CITY OF ALBUQUERQUE

May 7, 2019

RE: **Backyard Biergarten**
1320 2nd St NW
Grading and Drainage Plan Stamp Date: 4/26/19
Hydrology File: J14D046

C101

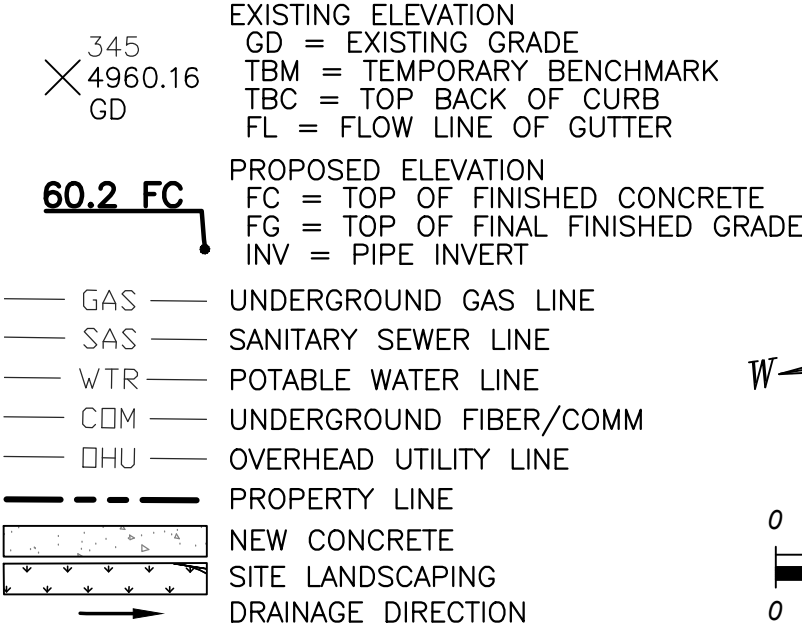
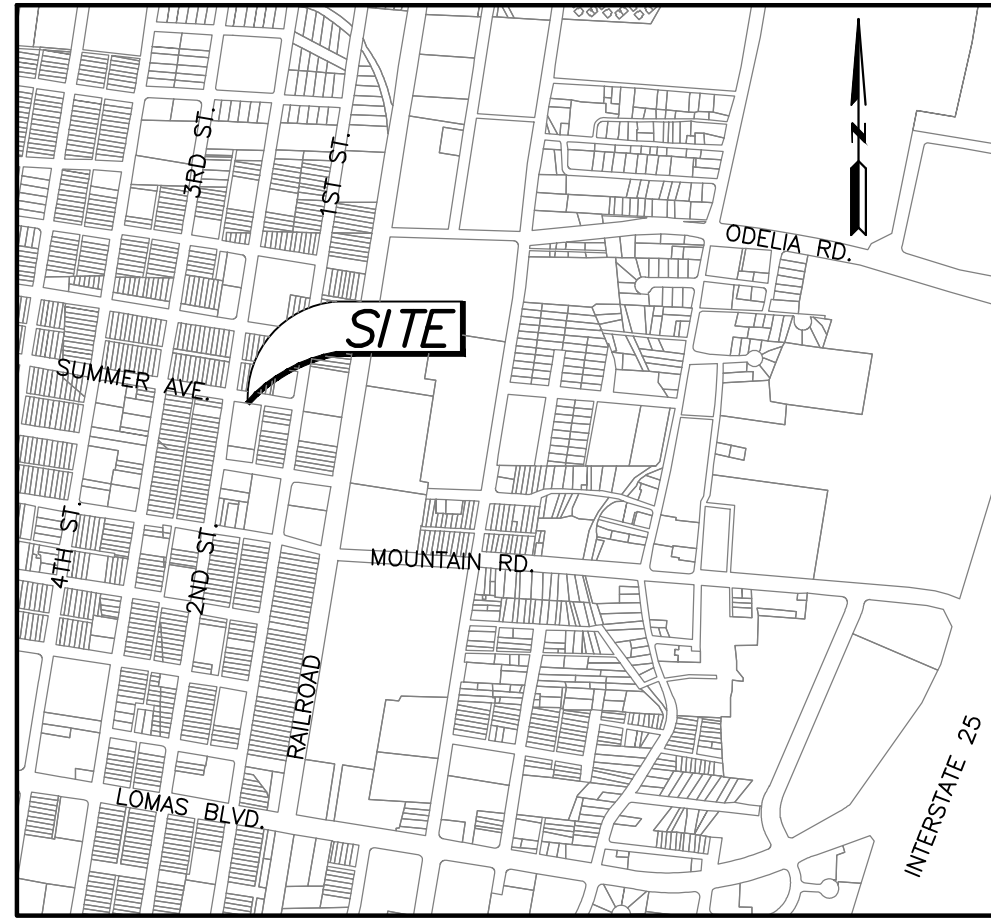
1. This site qualifies as redevelopment and is only required to retain runoff from the 80th percentile storm (Volume = 0.26”*Imp.Area).
2. The storm water quality (SWQ) retention facilities (pond, cisterns, etc.) need to be sized for the area draining to them. Locating the pervious parking lot on the uphill side of the project does not meet the storage requirement as no impervious area will drain to it. Runoff from all impervious area must be captured.

7. Only one paper copy of the submittal is required.
8. Increase the density of proposed spot elevations, especially along the property lines. Per the DPM Ch 22.7 *Grading Plan Checklist*, for flat sites supplemental spot elevations are required to adequately illustrate the proposed grading of the site.

9. For trash enclosures serving food service developments, demonstrate *control of liquids from dumpster areas* per DPM Chapter 22.9.E, Table 1 by containing runoff from the dumpster area and discharging to the sanitary sewer. If this information is on the utility plan please provide it, or show on the grading plan.

10. Include project benchmark and datum.
